Response to Issues – Department of Planning and Environment

21 Honeysuckle Drive, Newcastle – SSD 8019

7.4 Views From The Sun - Winter Solstice - 21/06/2017

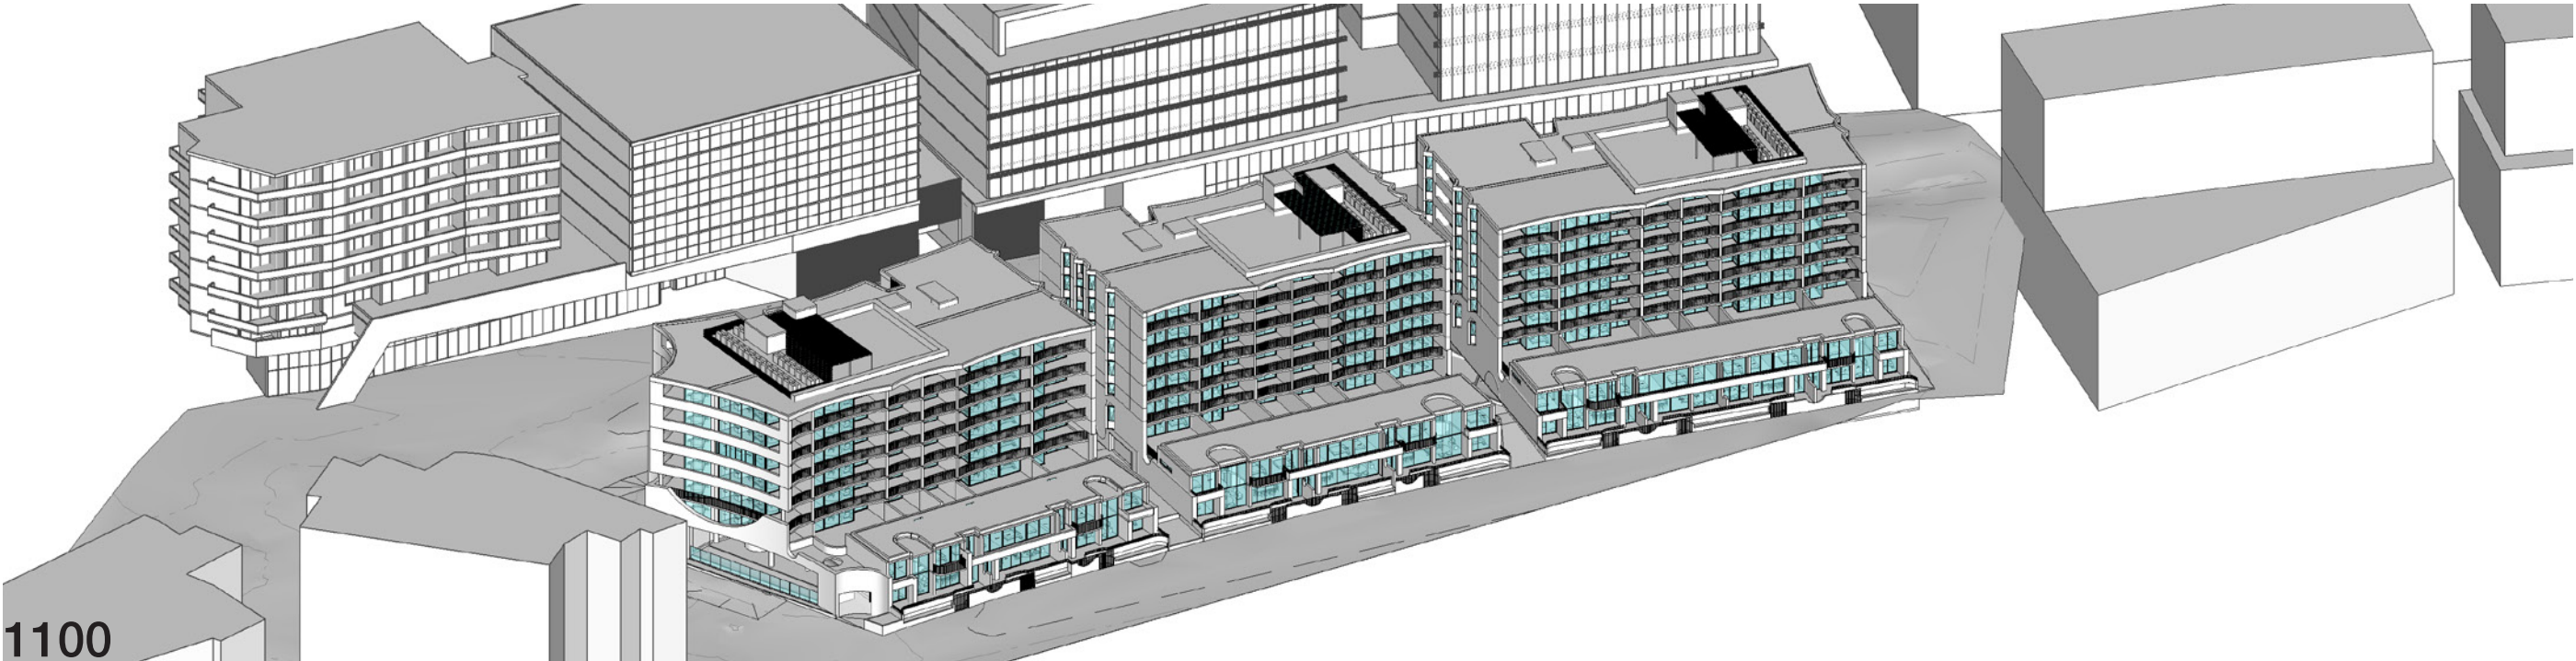
Particulars of Issues	Response	Attachment
<i>The overshadowing impacts of the proposal should be reviewed, including confirmation of overshadowing to the south between 1:00pm and 3:00pm, and that the apartments achieve a minimum of two (2) hours solar access in midwinter. In particular, assessment should detail solar access to apartments at Level 1, having regard to all structures in their proximity, including balcony overhangs, and the location of the terraces to the north.</i>	Updated view from sun and shadow diagrams in have been prepared by SJB Architecture, confirming that 75.3% of apartments receive a minimum of two (2) hours solar access.	Refer to: <ul style="list-style-type: none"> Attachment 1: Revised Architectural Drawing Package; and Attachment 2: Built Form Analysis.
Noise		
<p><i>A supplementary acoustic assessment should be provided addressing:</i></p> <ul style="list-style-type: none"> <i>The potential design options to achieve nominated noise criteria should be provided, including façade design, opening sizes, room volumes and finishes;</i> <i>Potential treatments to mitigate noise impacts from mechanical plant and equipment;</i> <i>Potential mitigation measures for construction noise and vibration impacts to be incorporated into the construction program</i> <i>The impact of noise from Port activities on the proposed residential development, and any mitigation measures required to ensure satisfactory acoustic amenity for future residents.</i> 	An updated Acoustic Assessment undertaken by Renzo Tonin & Associates forms part of this resubmission. If required, additional acoustic information can be provided by way of condition.	Refer to: <ul style="list-style-type: none"> Attachment 6: Acoustic Report.
